From: Peter Valcourt <peter.valcourt@yahoo.com>
To: Ann Machado <AMACHADO@portlandmaine.gov>
Date: 5/12/2015 1:58 PM
Subject: Re: 23 Emerson St - Permit #2015-00675

> Zoning Administrator

Attic/Roof Plan

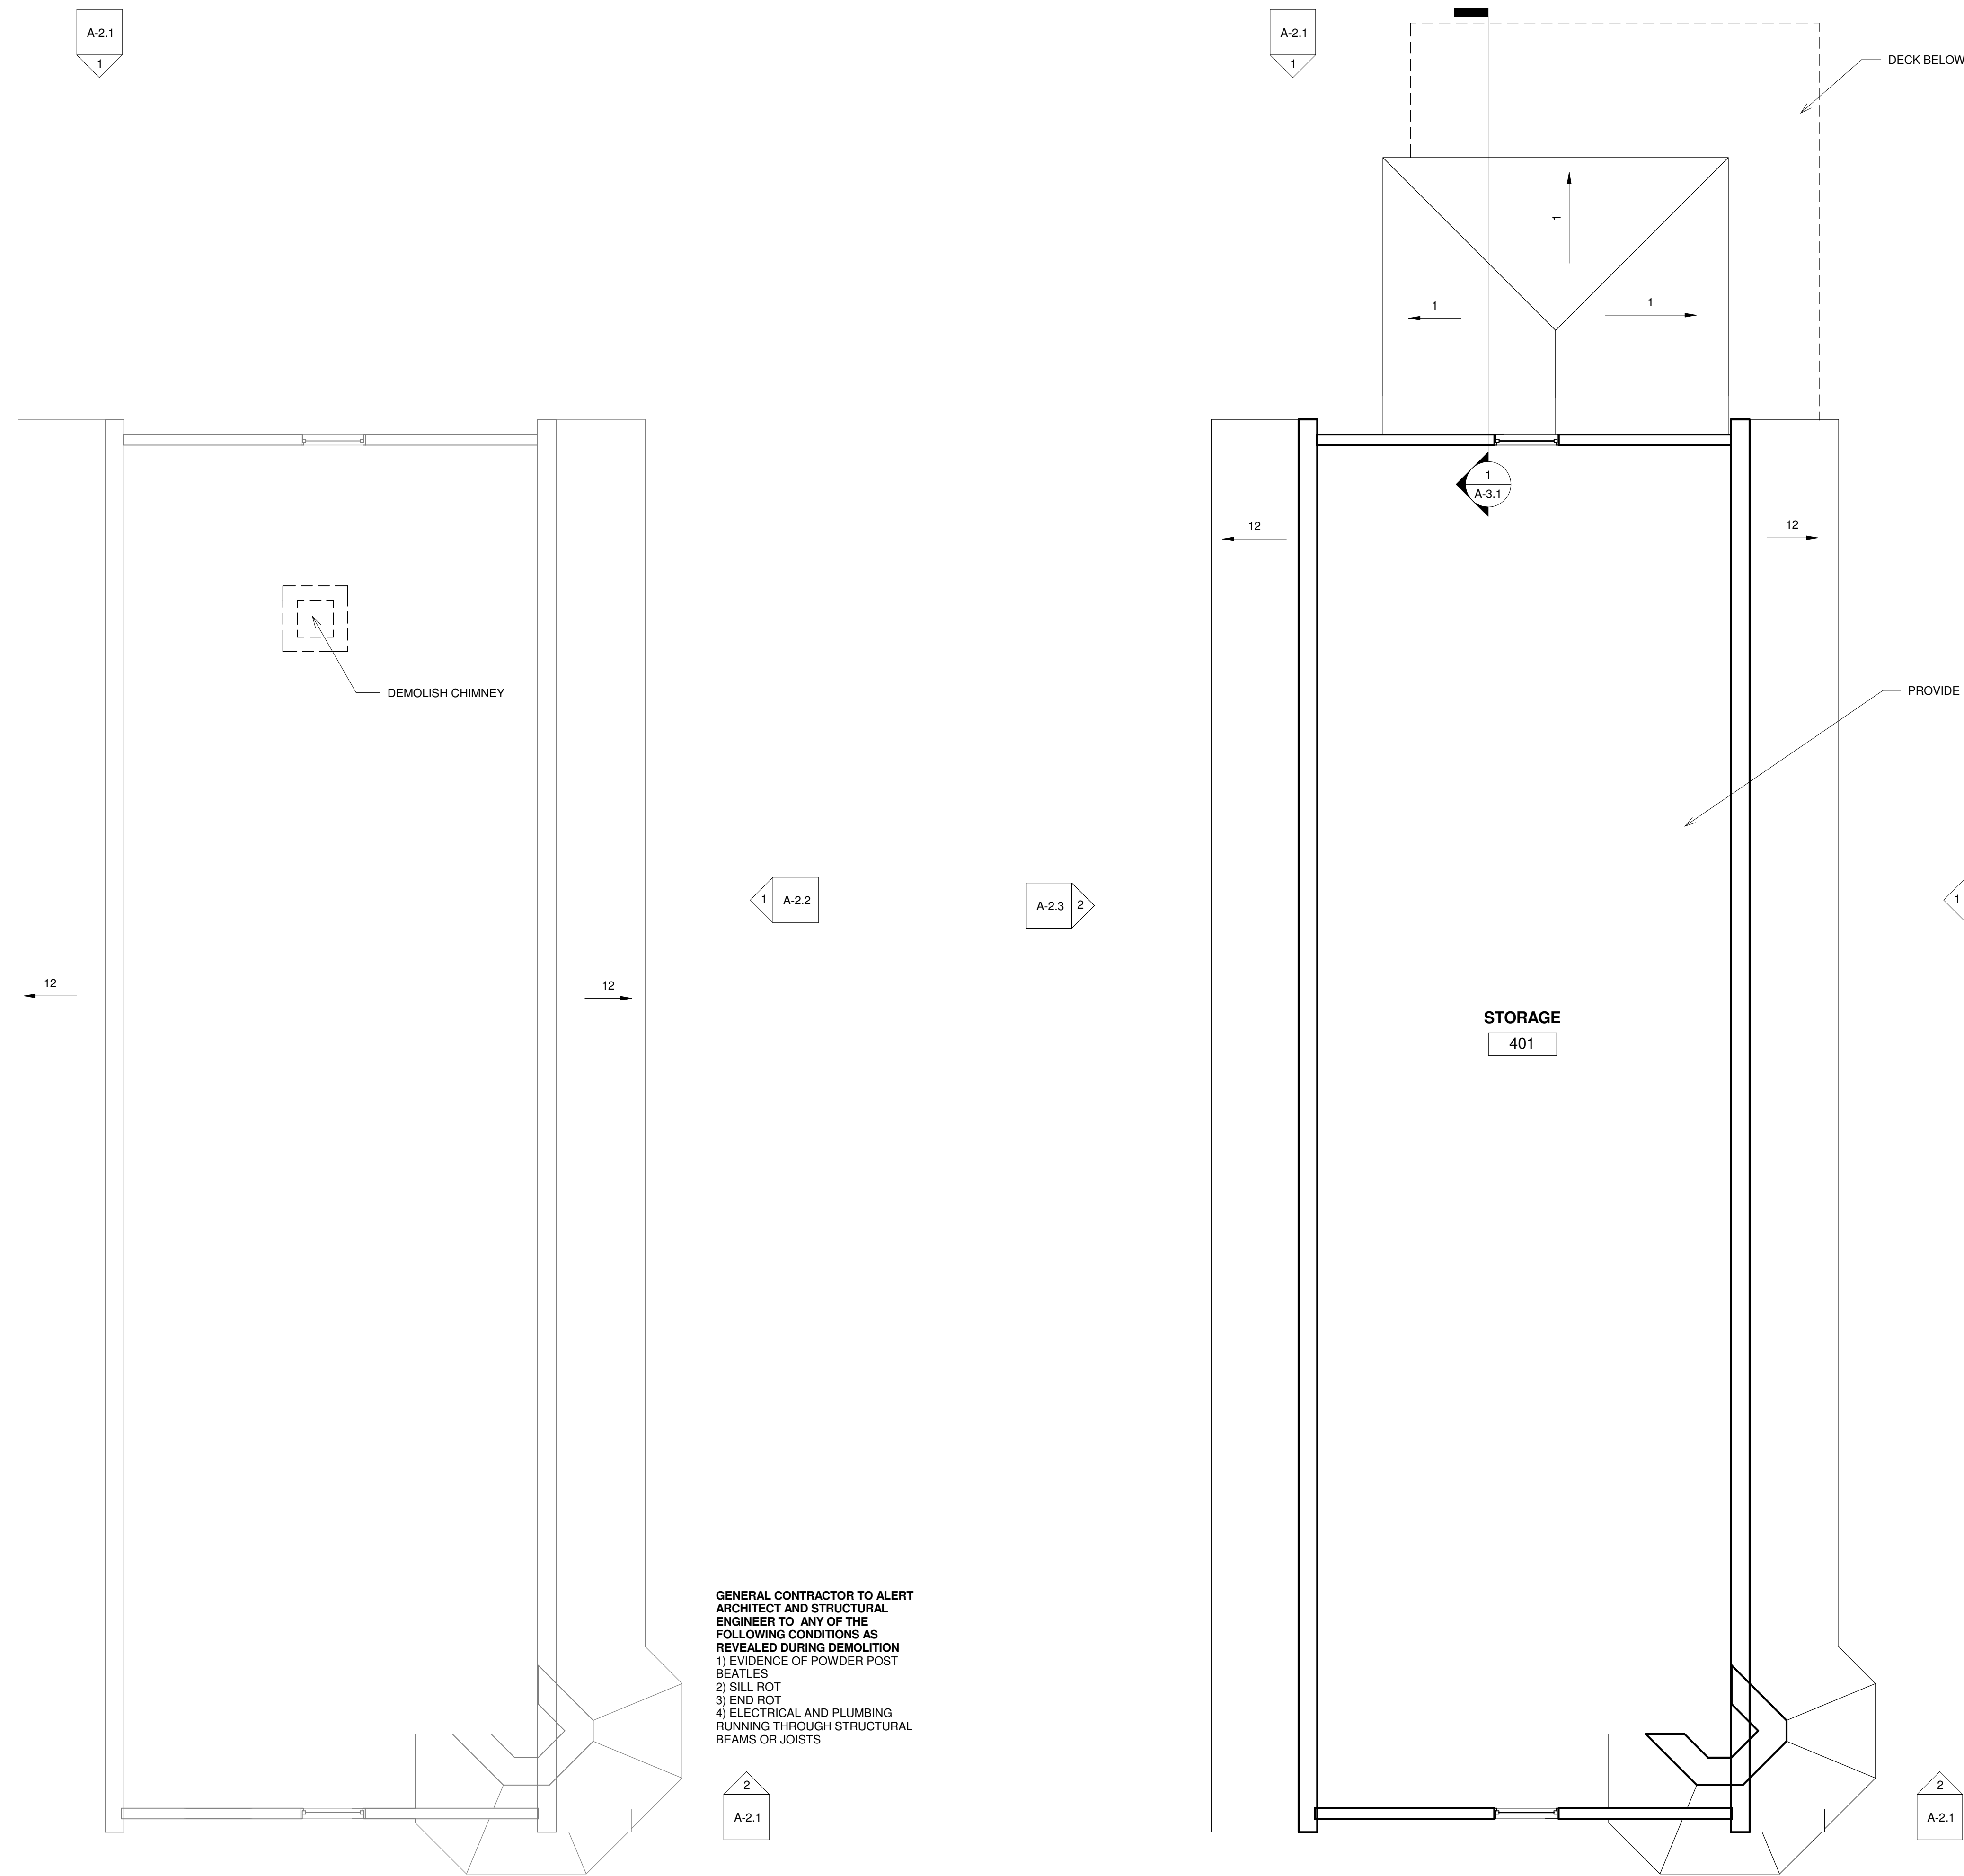
> When a garage is nonconforming, it needs to be rebuilt in the same footprint and shell. The footprint is the same but the roof is changing from a hip roof to a gable roof. Is the height of the ridge (14')staying the same? Is the height of the wall staying at 9'? If these two heights are staying the same then the change in the roof style will be OK.

Thanks anne. Yes we are keeping the same height as existing garage.
